# Final Drainage Report

## McGehee Tract El Paso County, Colorado

April, 2021

PCD No. SF2011

Exhibit 10: Historic Drainage Conditions (map pocket)

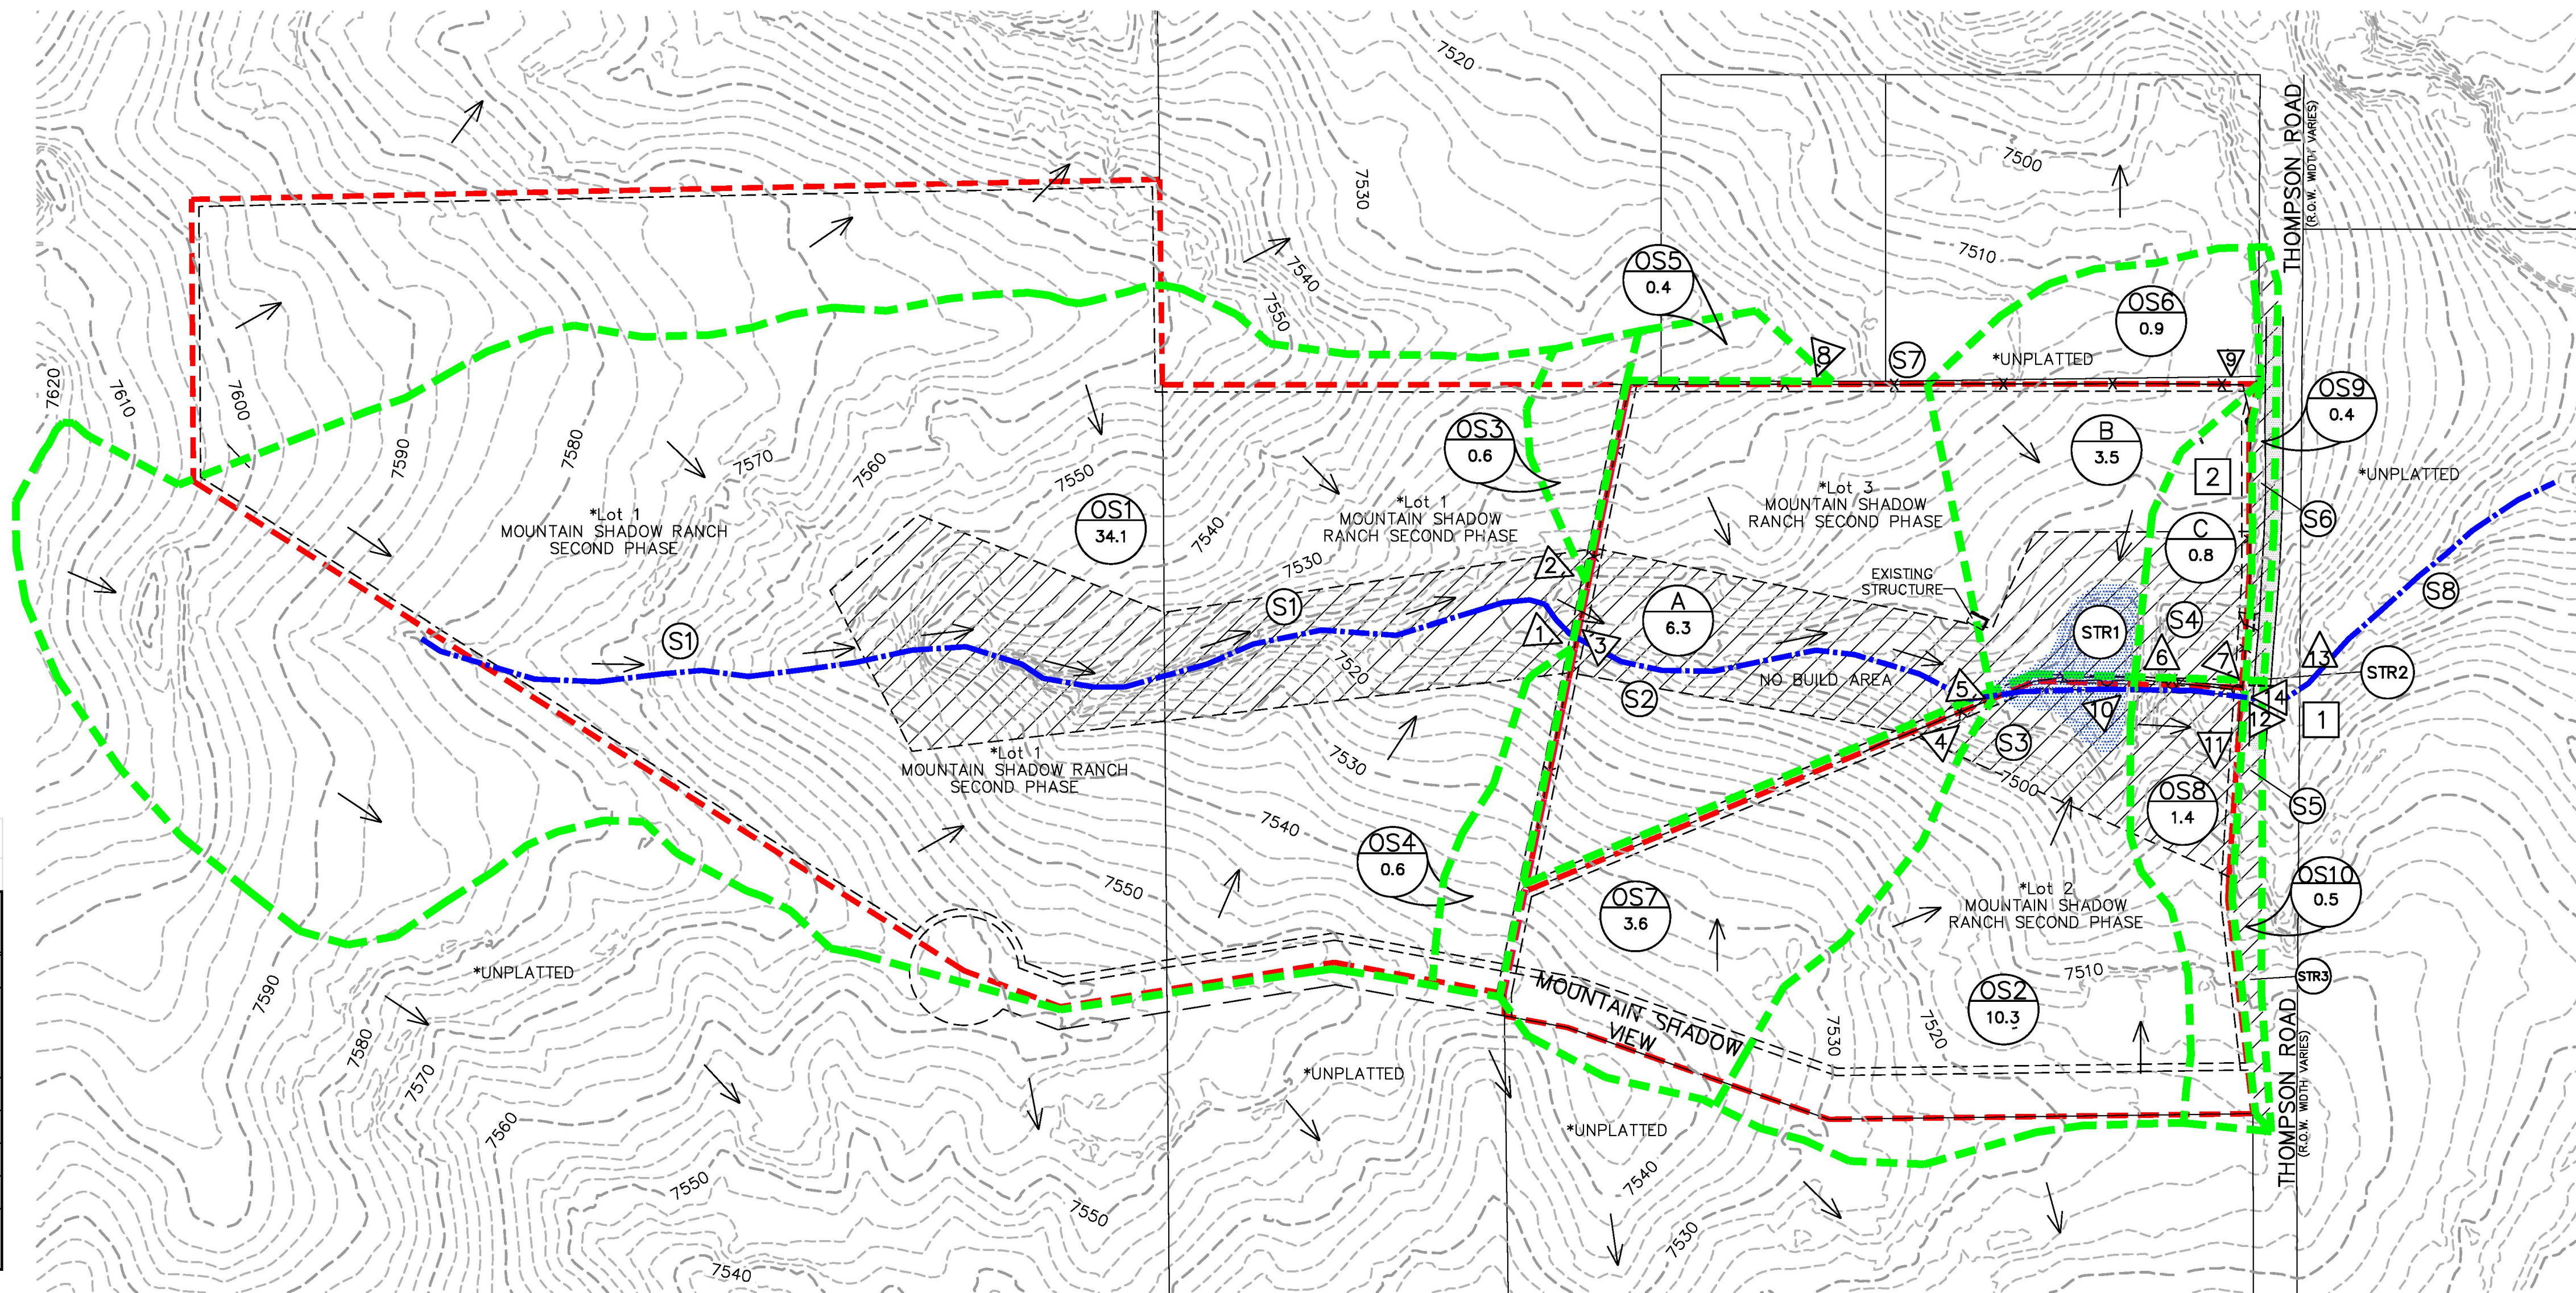
What about S3 that is shown on the map?  
Discuss or revise text/map as necessary.
